CITY OF ALBUQUERQUE  
 PLANNING DEPARTMENT  
 DEVELOPMENT REVIEW BOARD

December 4, 2013

**Project# 1009506**

Project#1009506 – Lots 14-19 Volcano Cliffs Unit 6 (tbka Montecito West **Unit 2**)

PRELIMINARY PLAT FOR
MONTECITO WEST UNIT 2
 LOTS 1 - 48 & TRACTS 1 - 4
 CITY OF ALBUQUERQUE
 BERNALILLO COUNTY, NEW MEXICO
 NOVEMBER, 2013

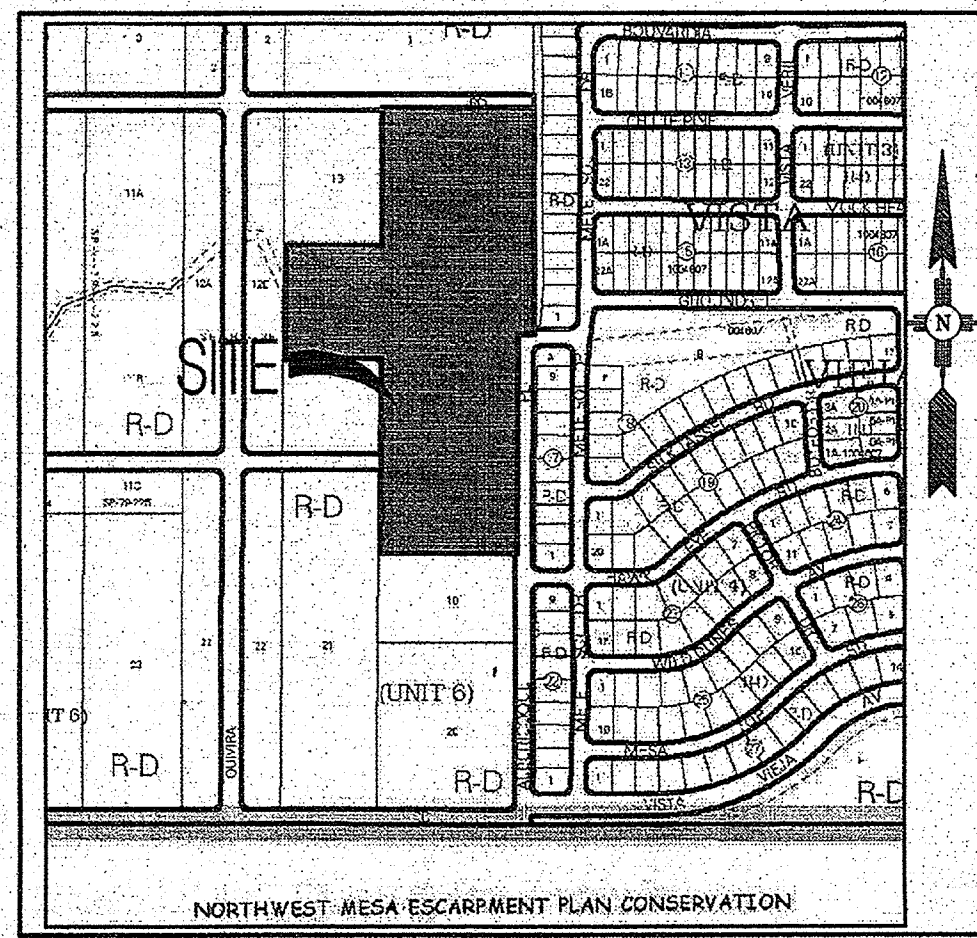
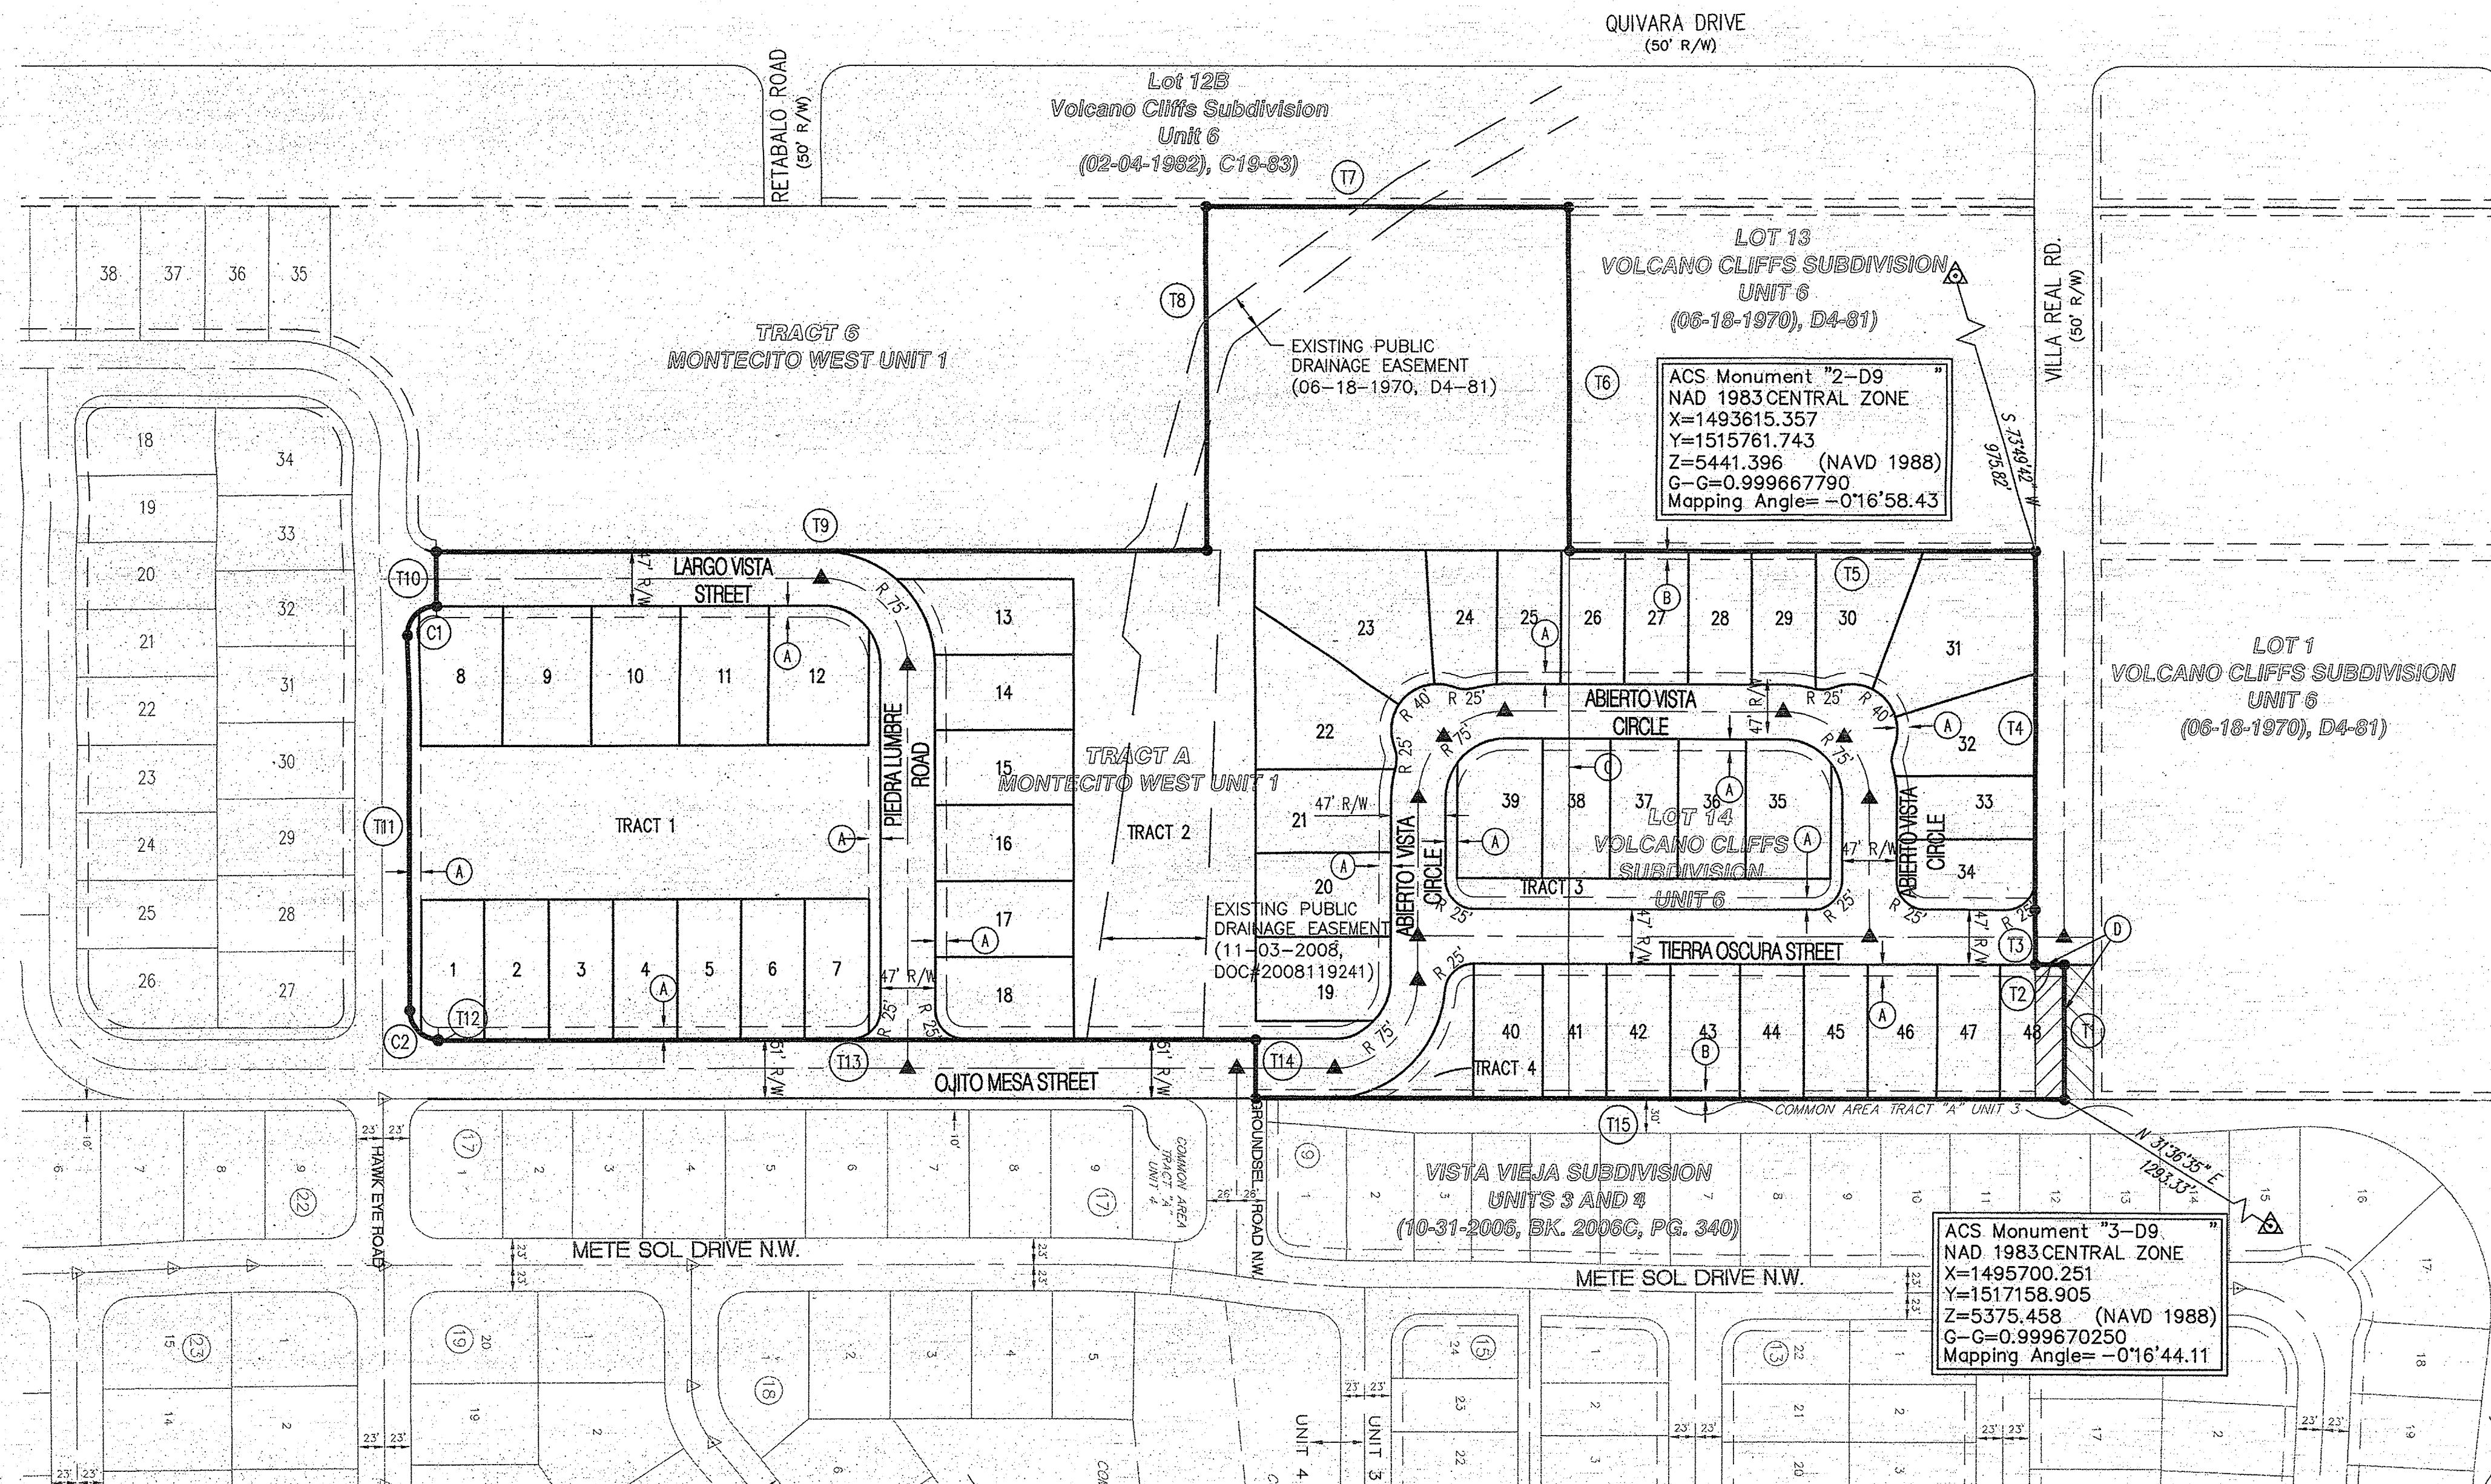
- a. More information is needed regarding the 2 HOA tracts and the 2 Private Common Area tracts.
- b. Parks & Recreation's Open Space Division requests that the Parceled Commons Areas Tracts 1 and 2 be dedicated to the City to be managed as public Open Space by the Open Space Division. Please change General Notes #6 to reflect this change.

- c. The Public Open Space will need to be fenced with open space fencing prior to construction of adjacent infrastructure and residential lots to prevent damage to existing vegetation. Fencing to be added to Infrastructure List.

- d. Please change all references to Private Commons Areas (PCA) as the name has been changed to Parceled Common Areas (PCA) within Private Commons Development (PCD). Per the Ordinance, Parceled Common Areas can be Public or Privately owned and maintained. In this request, the Parceled Commons Areas shall be Public Parceled Commons Areas.

- e. Provide note in General Notes stating the responsibility of the HOA to maintain the 2 HOA tracts.
- f. Line weights in the Legend are difficult to differentiate on the Plat.

MONTECITO WEST UNIT 2 TOTAL ACREAGE	16.5407 ACRES
LOTS, STREETS, HOA TRACTS	11.5516 ACRES
TRACTS 1-2, PARCELED COMMONS AREA	4.9891 ACRES
% PARCELED COMMONS AREA OPEN SPACE	30.18%
NUMBER OF LOTS	48
DENSITY	2.9 DU/AC

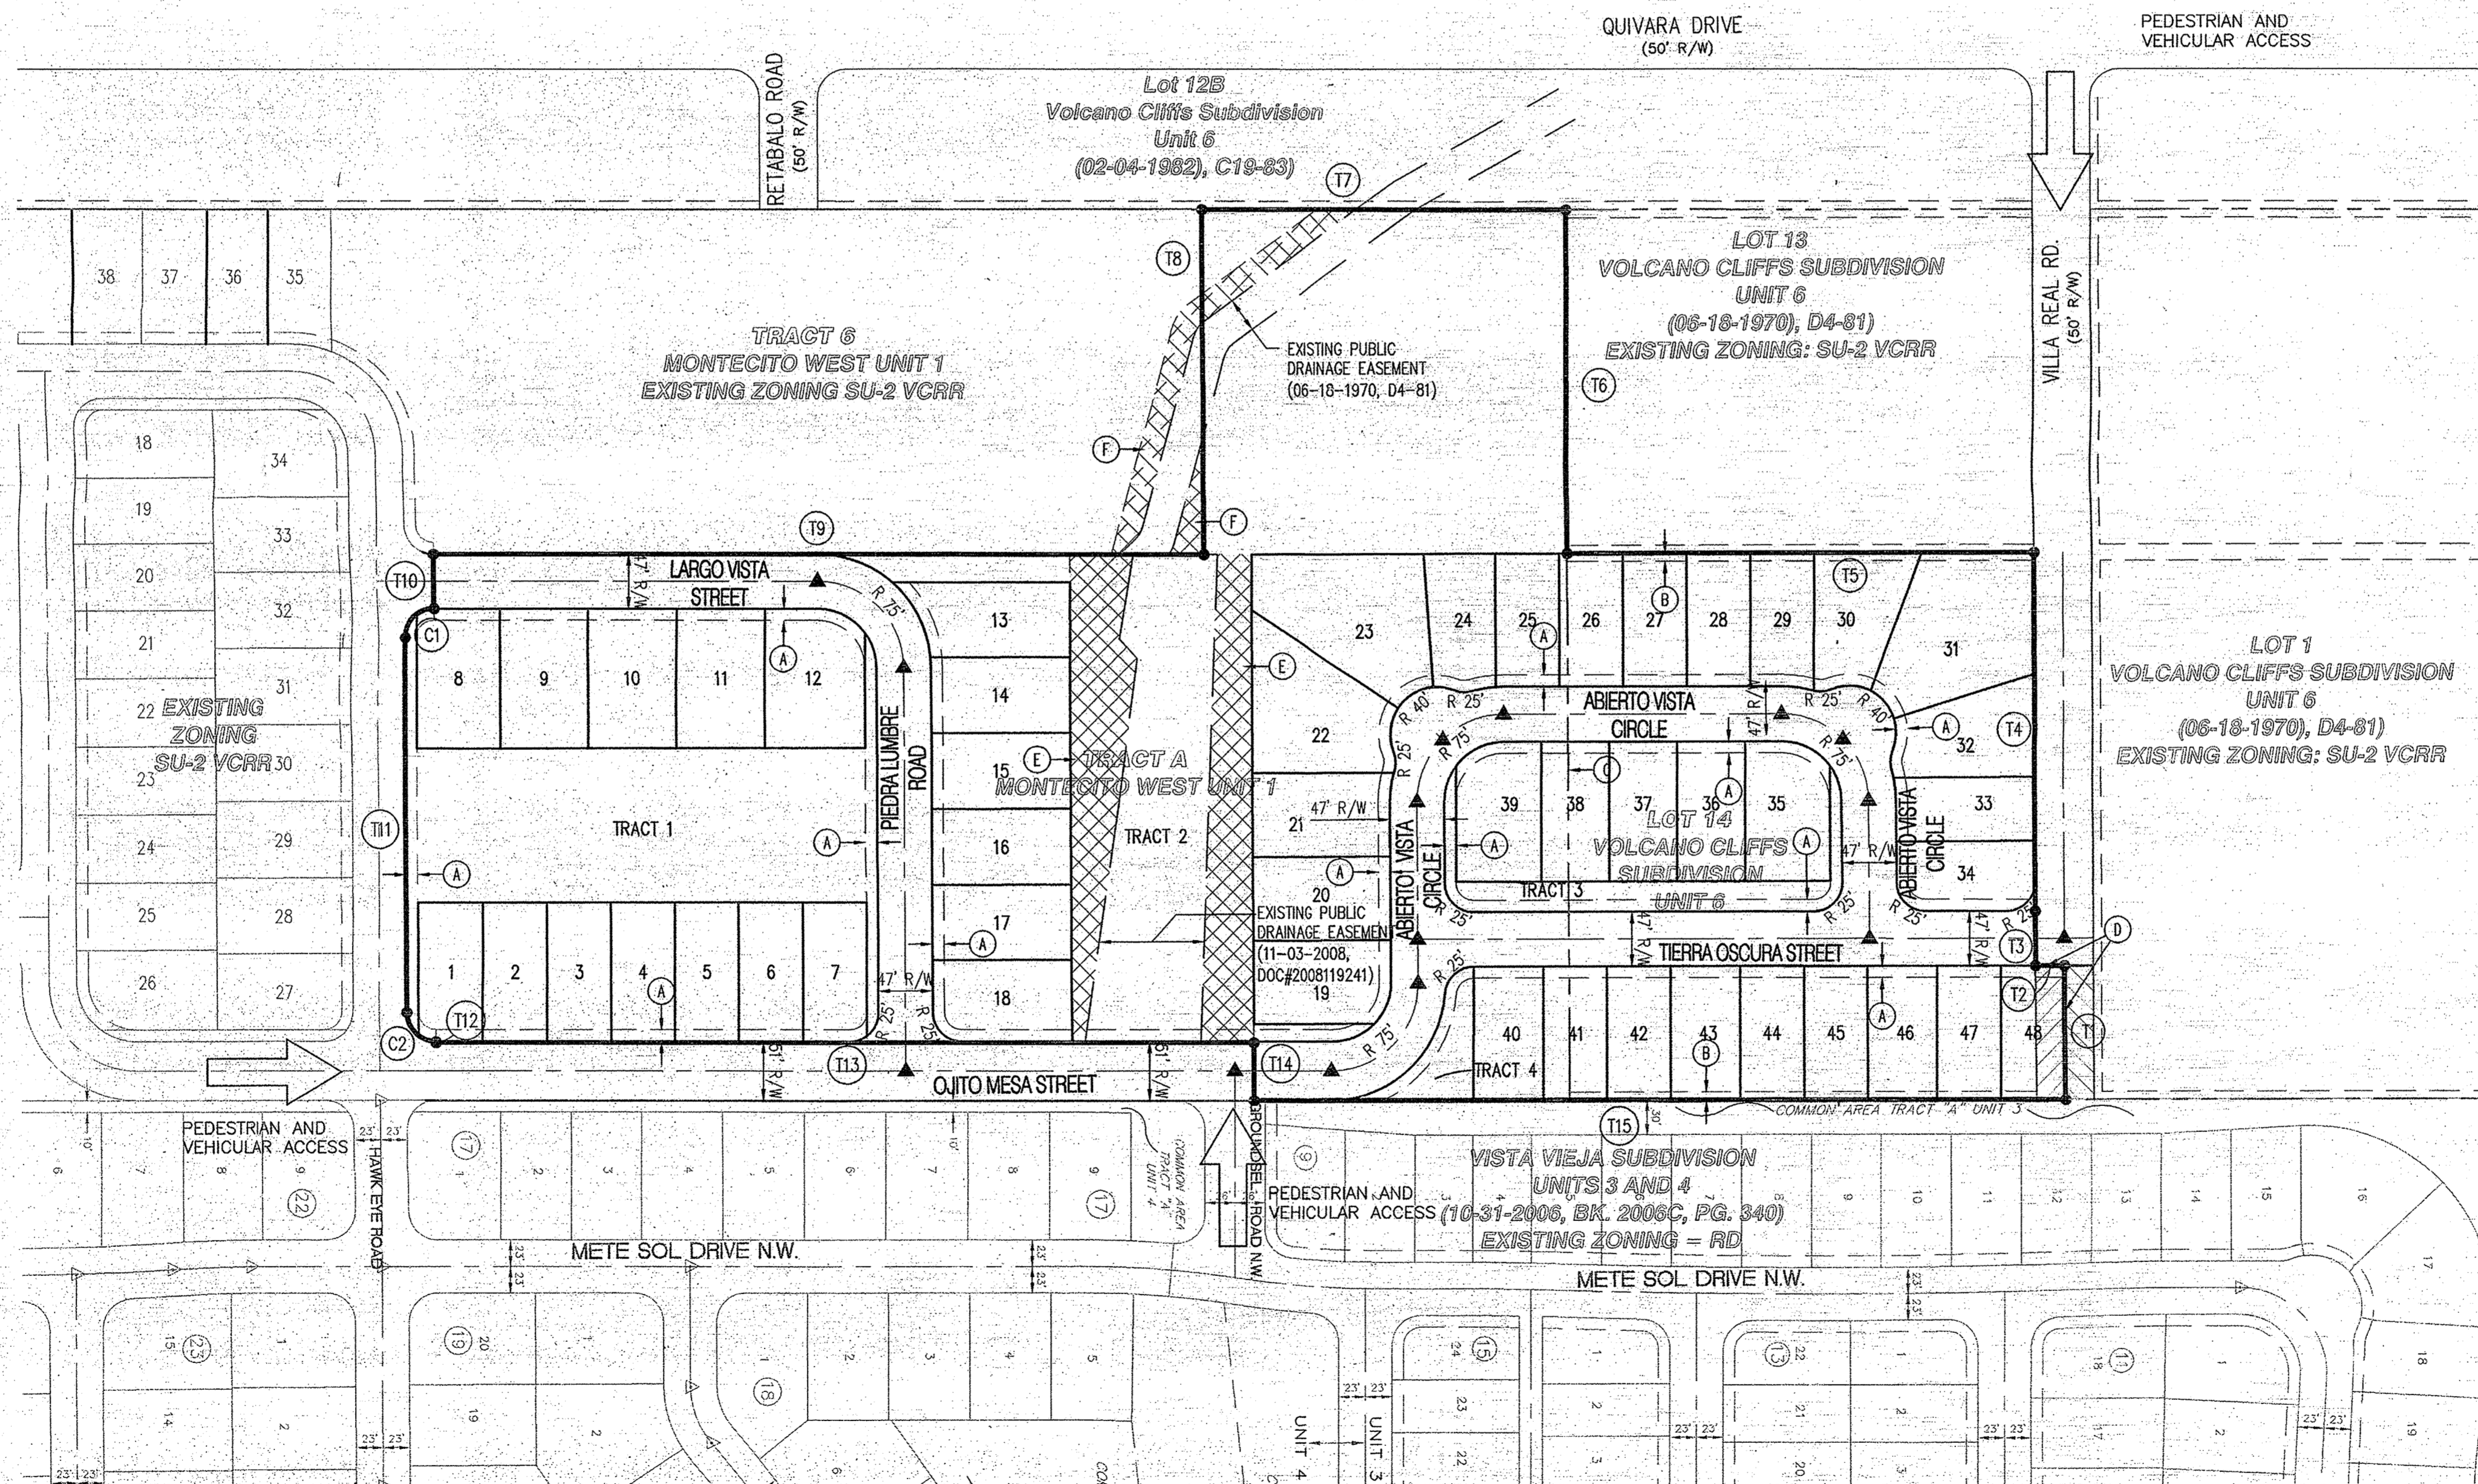
- a. More information is needed regarding the 2 HOA tracts and the 2 Private Common Area tracts.
- b. Parks & Recreation's Open Space Division requests that the Parceled Commons Areas Tracts 1 & 2 be dedicated to the City to be managed as public Open Space by the Open Space Division. Please change General Notes #6 to reflect this change.

- c. The Public Open Space will need to be fenced prior to construction of adjacent infrastructure and residential lots to prevent damage to existing vegetation.

- d. Please change all references to Private Commons Areas (PCA) as the name has been changed to Parceled Common Areas (PCA) within Private Commons Development (PCD). Per the Ordinance, Parceled Common Areas can be Public or Privately owned and maintained. In this request, the Parceled Commons Areas shall be Public Parceled Commons Areas.

- e. Provide note in General Notes stating the responsibility of the HOA to maintain the 2 HOA tracts.
